**Re: Subject: PA22-015 Colvin PRD  
3920 Densmore Road  
APN's: 00590700023505 & 00590700024400  
Core Project No. 21387**

The purpose of this letter is to provide a response to the review comments for PA22-015 Colvin PRD dated May 9, 2022. We have addressed each comment and revised the plan/documentation accordingly. This letter contains the review comments immediately followed by our response to each in bold lettering.

SHEET	OF
C4.01	7
PROJECT NUMBER	
21387

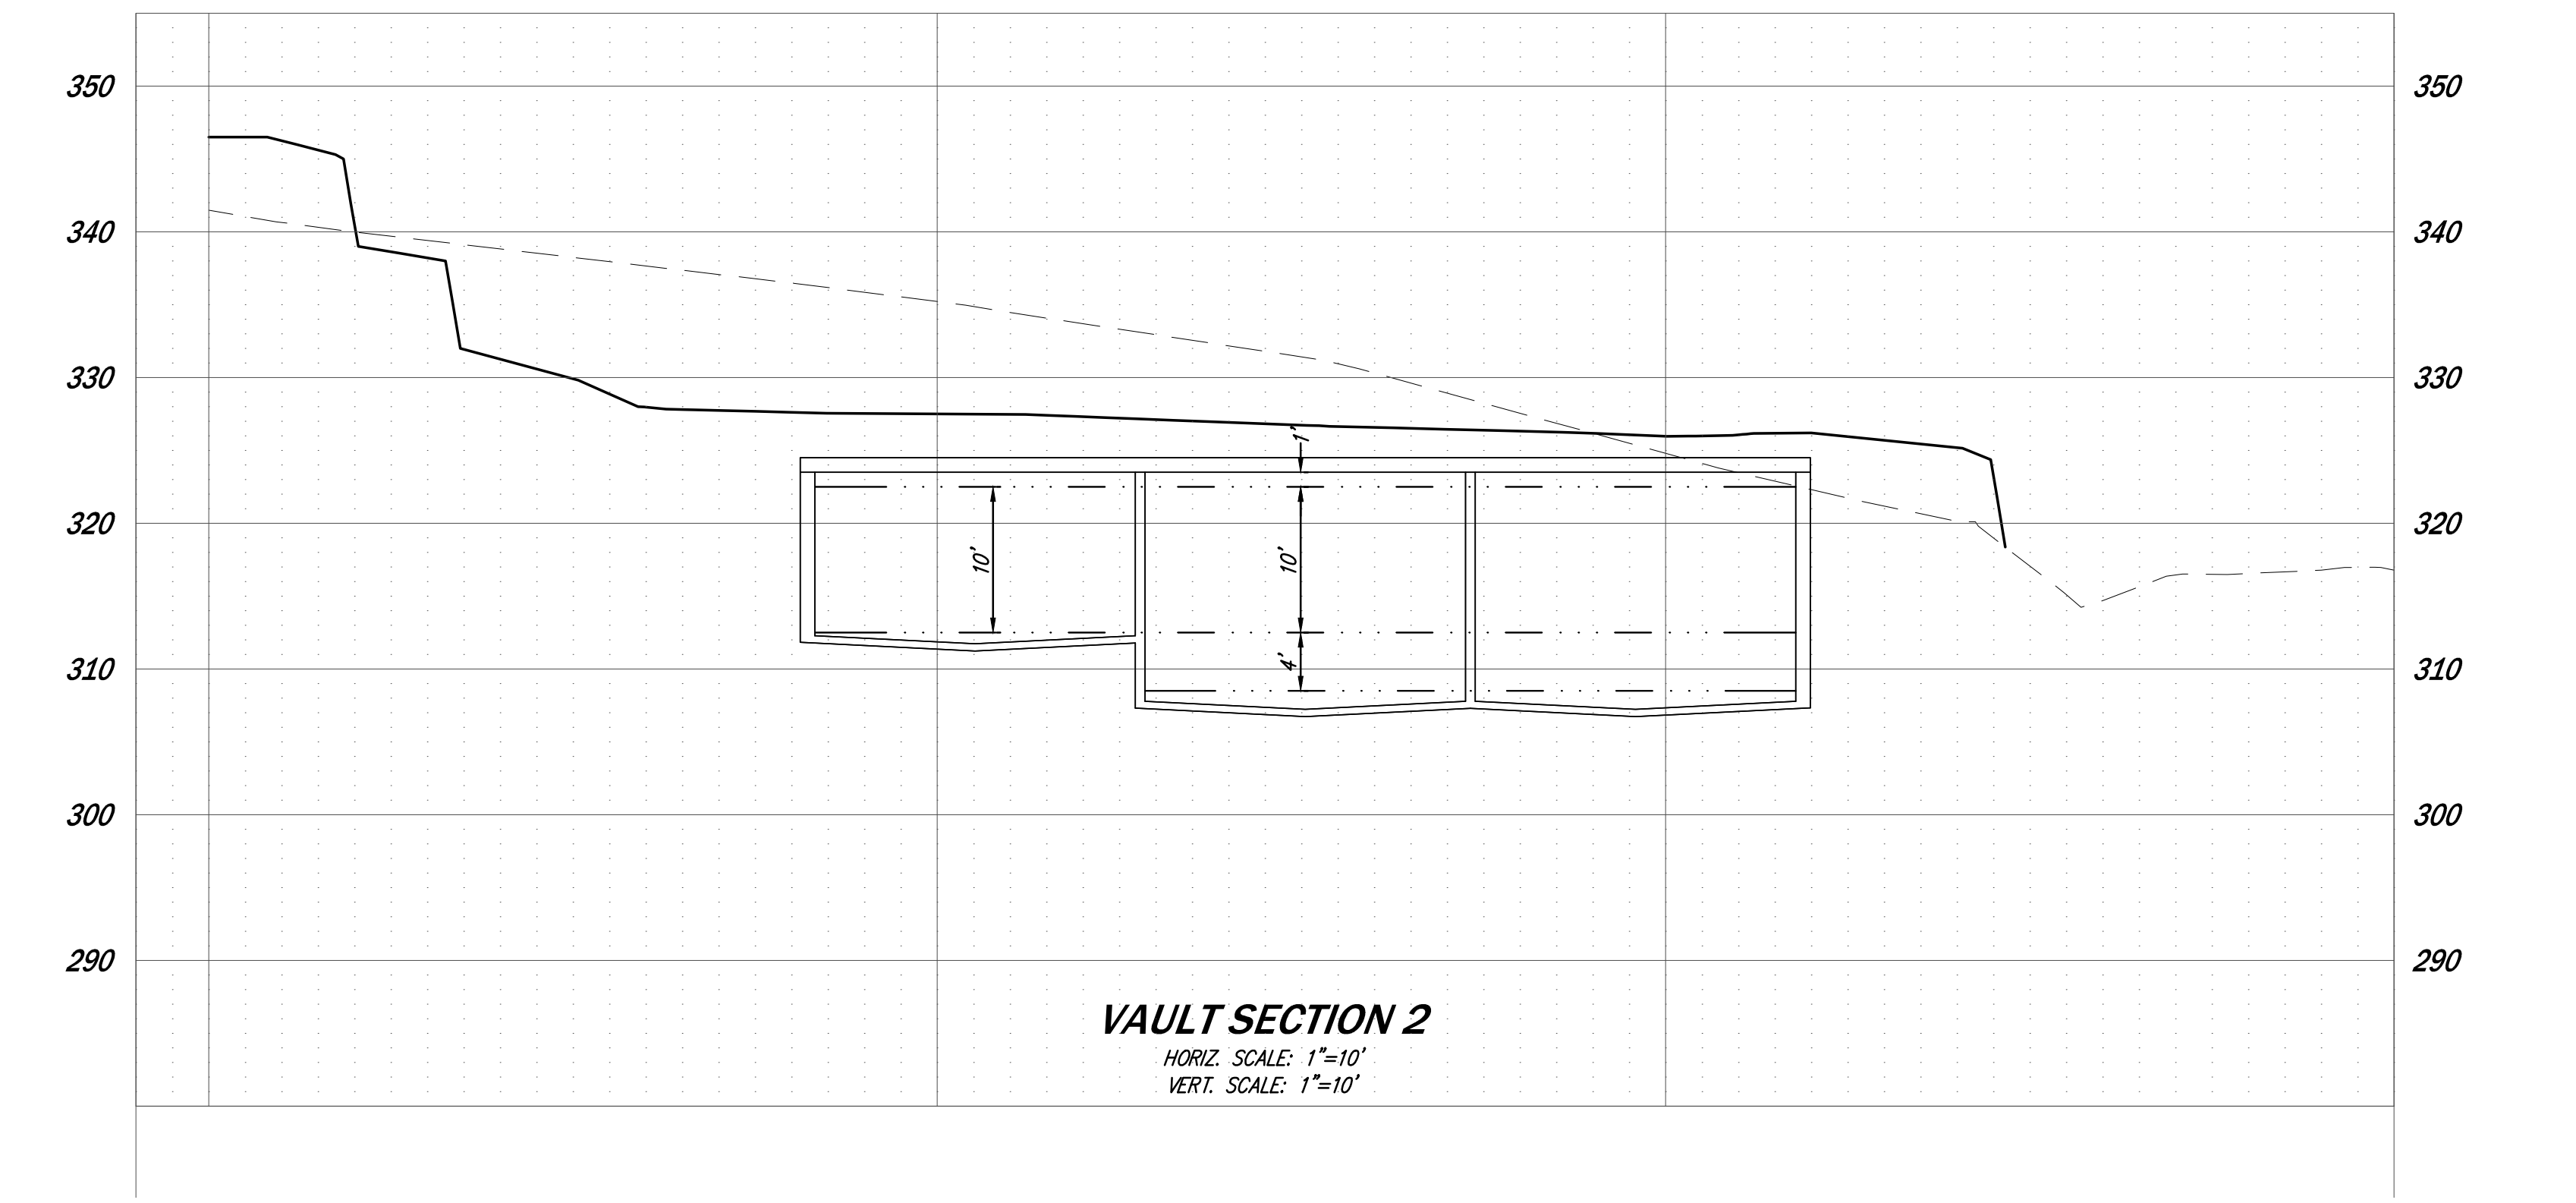
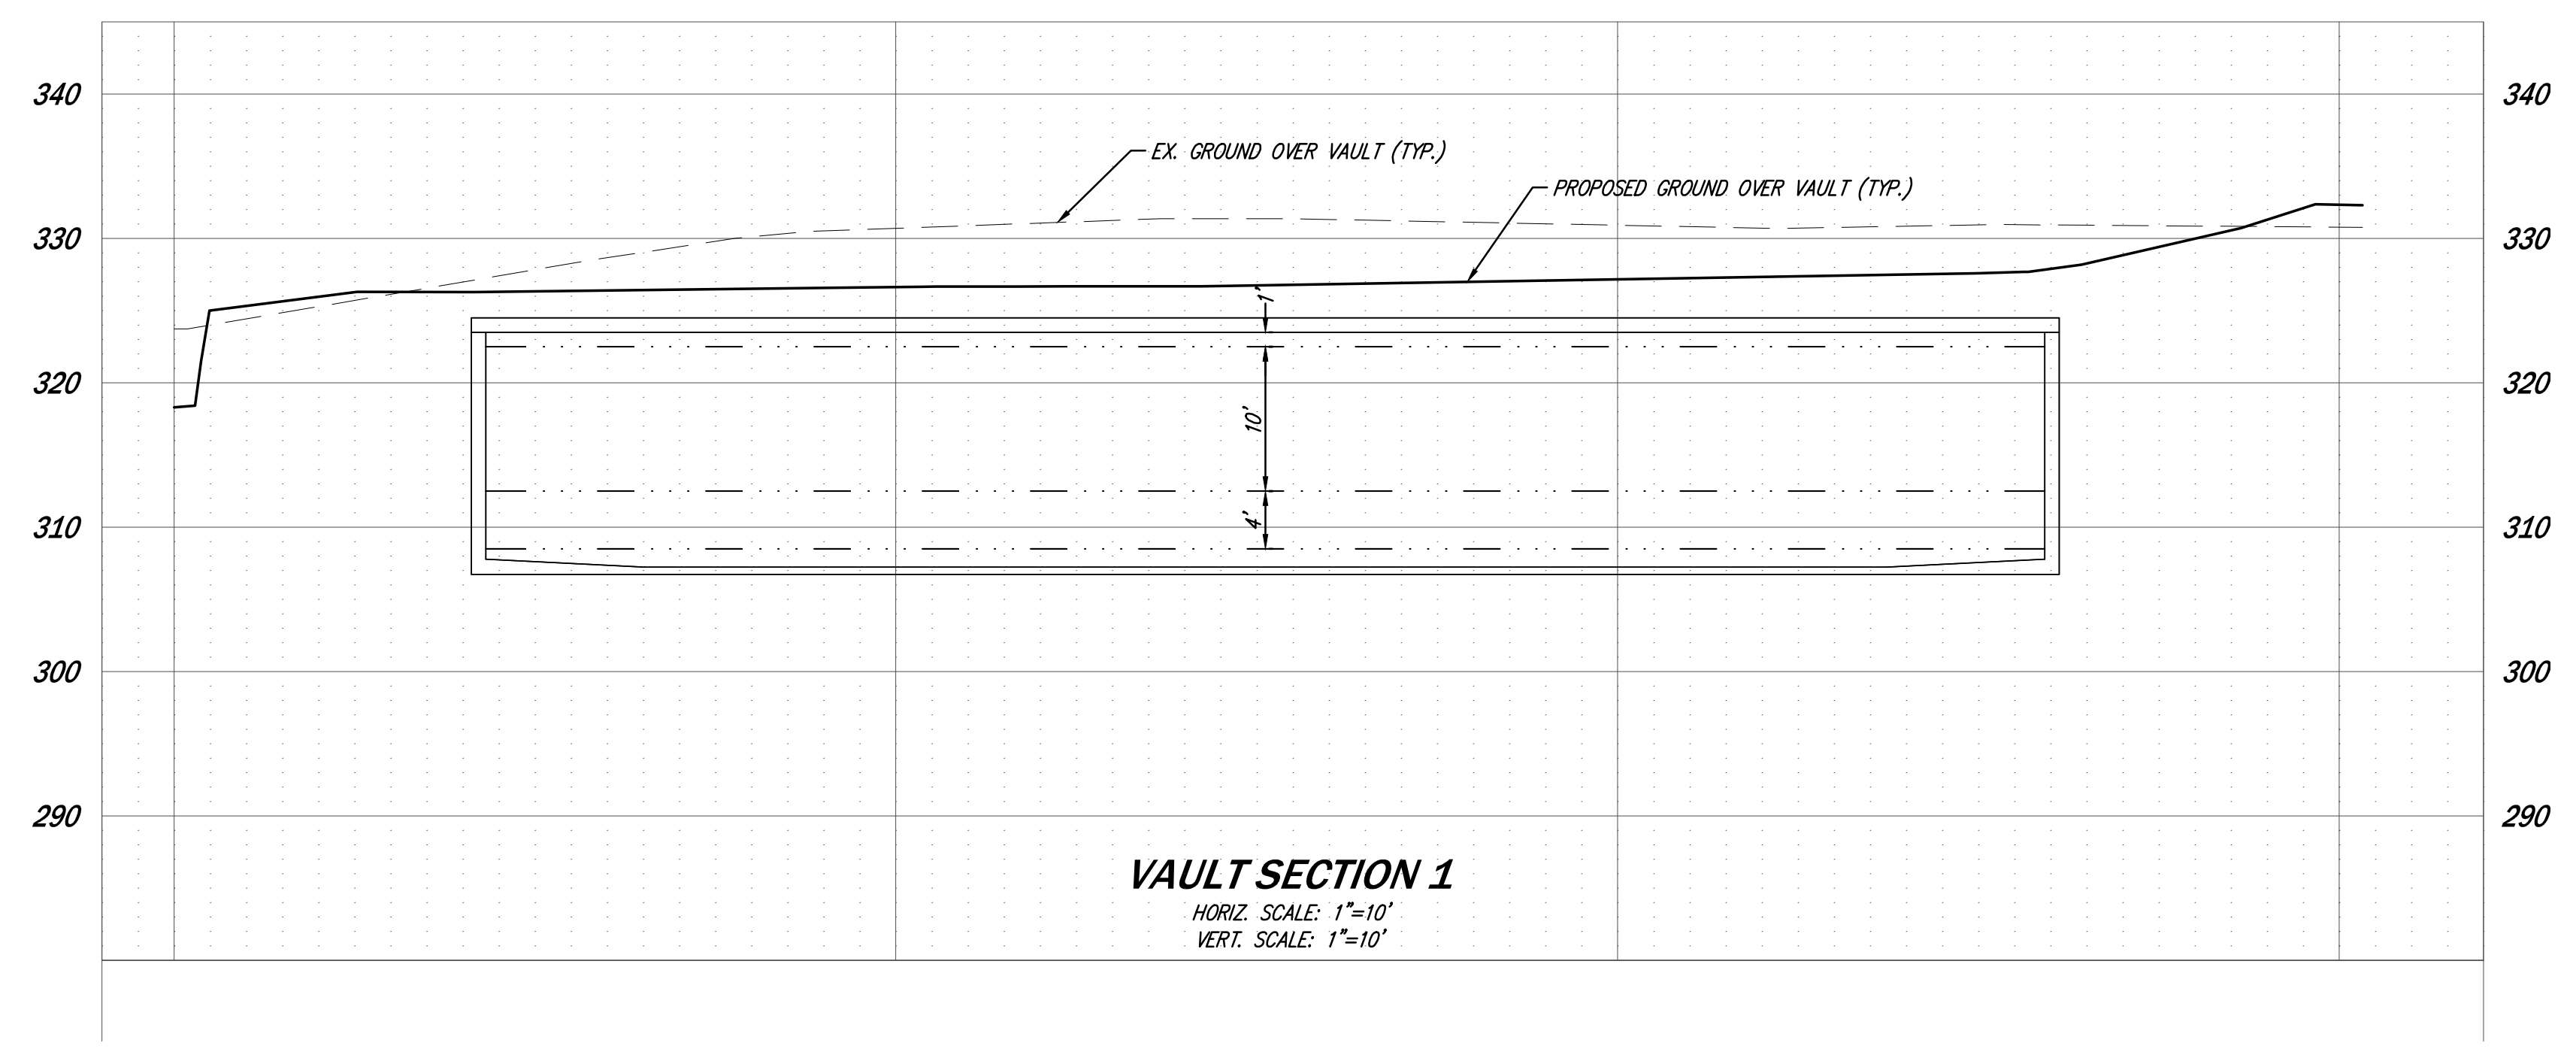
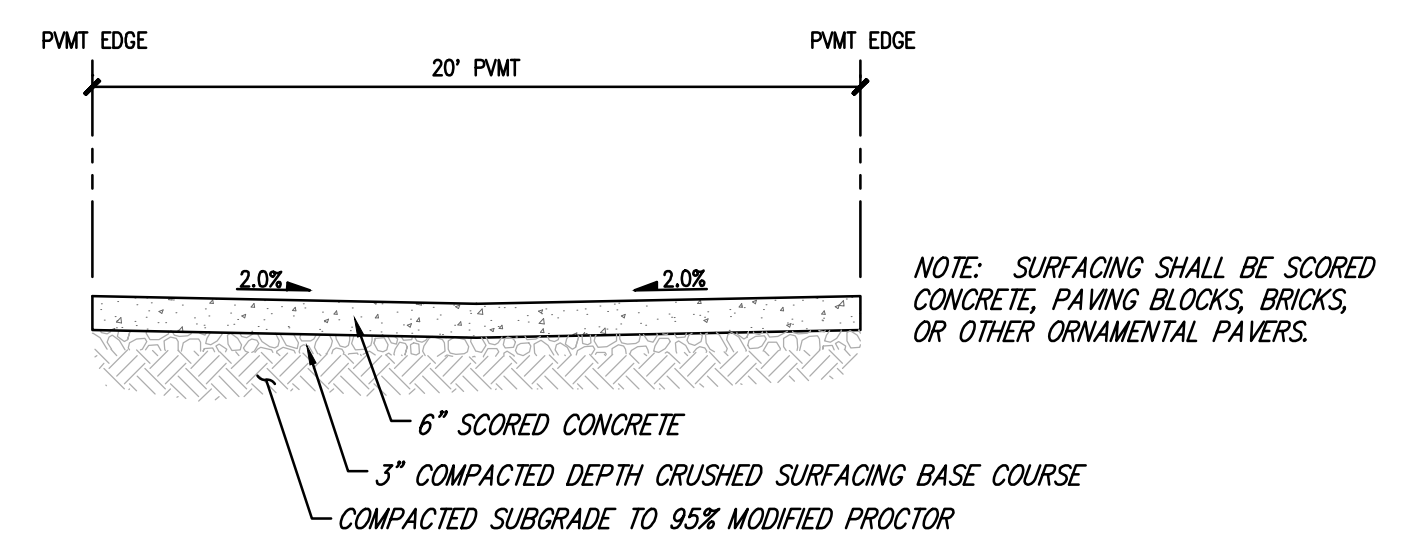
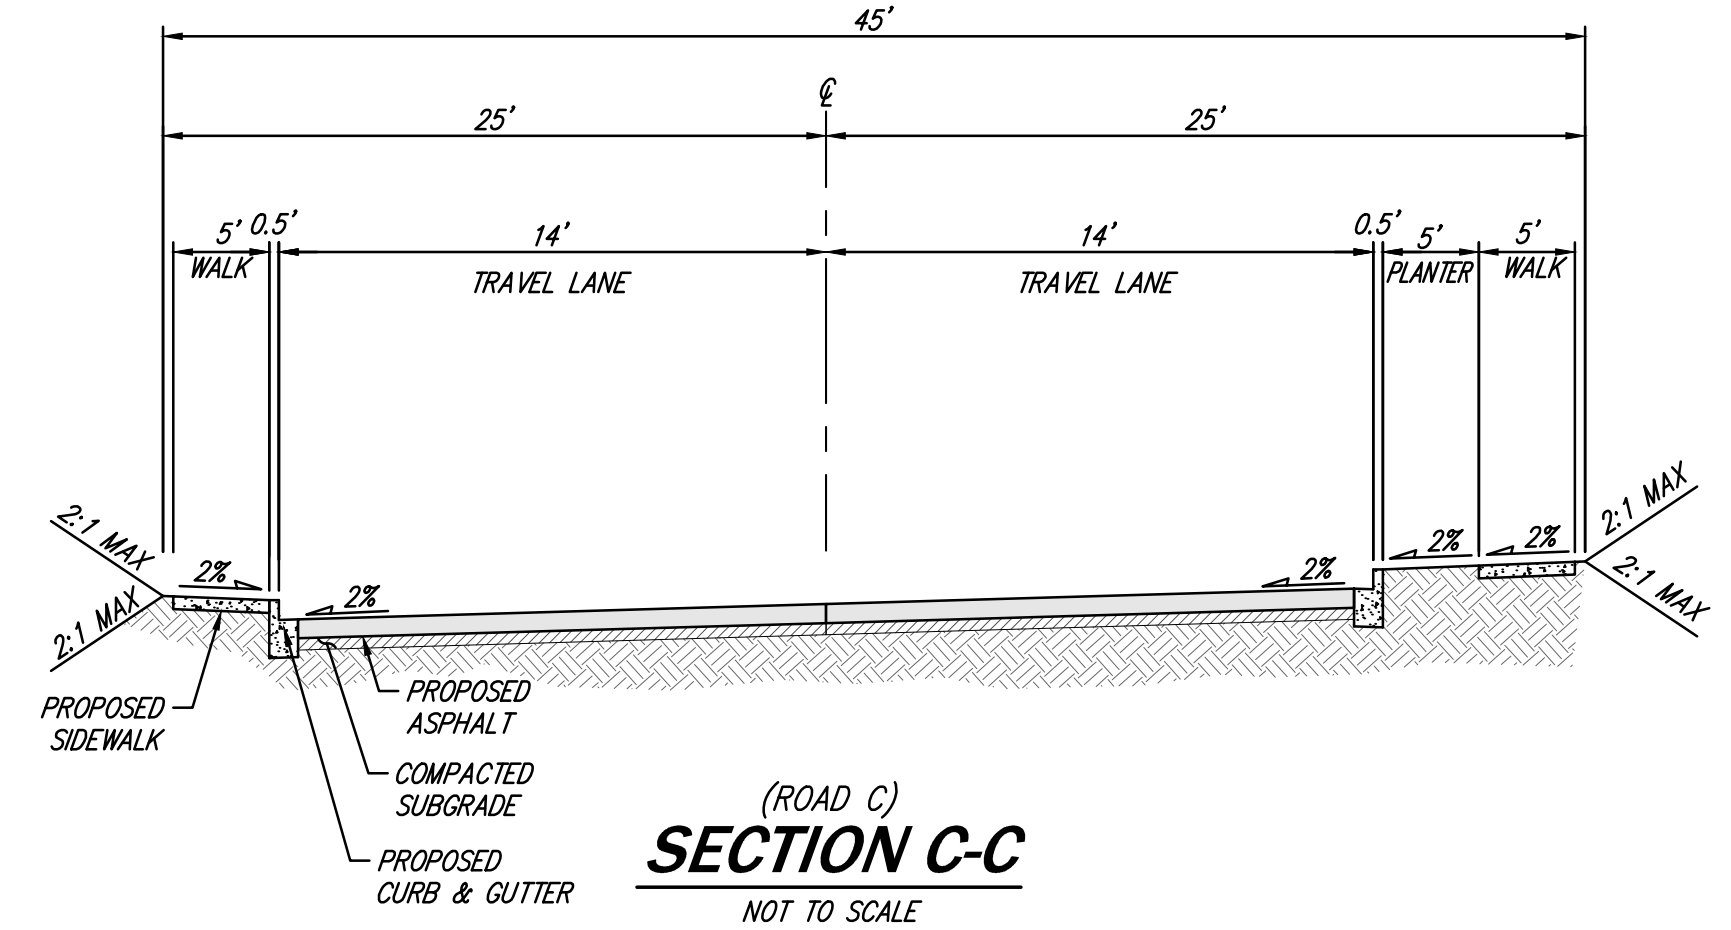
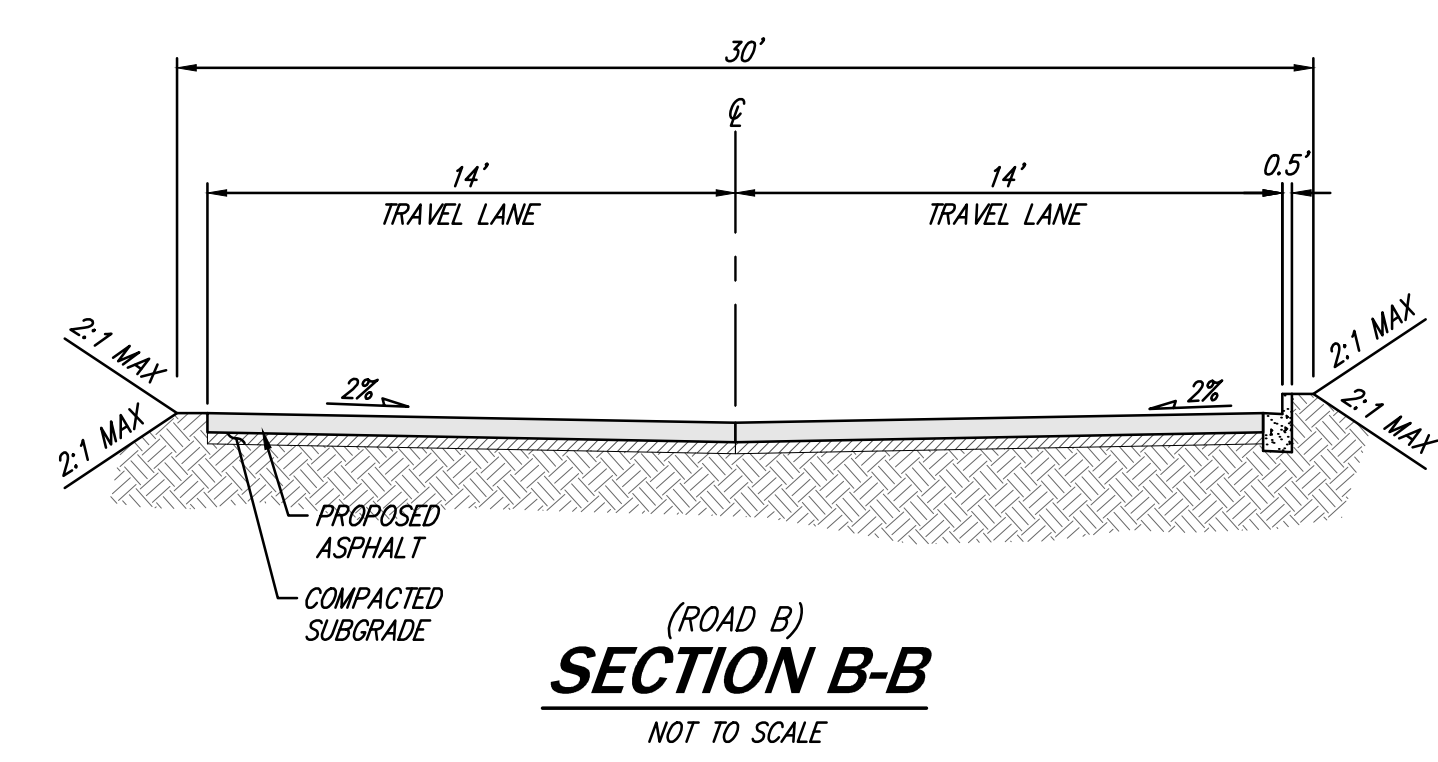
3. Based on review of Sheet C4.01, there appears to be multiple retaining walls exceeding the allowable 4 ft. threshold, which requires wall terracing. Please clarify how compliance with MMC 22D.050.030(4) is to be satisfied for the proposed retaining walls exceeding 4 ft. in height

***Response: Walls have been proposed with a max height of eight-feet. Walls exceeding four-feet in height have been designed so they are not be visible from neighboring properties. The eastern walls are proposed to be cut walls and are anticipated not to be visible from the eastern neighbors since they are at a higher elevation. The western walls are proposed to be fill walls and area also anticipated not be visible to the eastern neighbors. The only visual impact anticipated as a result of the walls would be to vehicle traffic and pedestrian traffic along Desnmore Road. Wall details and design will be provided by a geotechnical or structural engineer during Civil Review. If necessary, the applicant will apply for a deviation.***
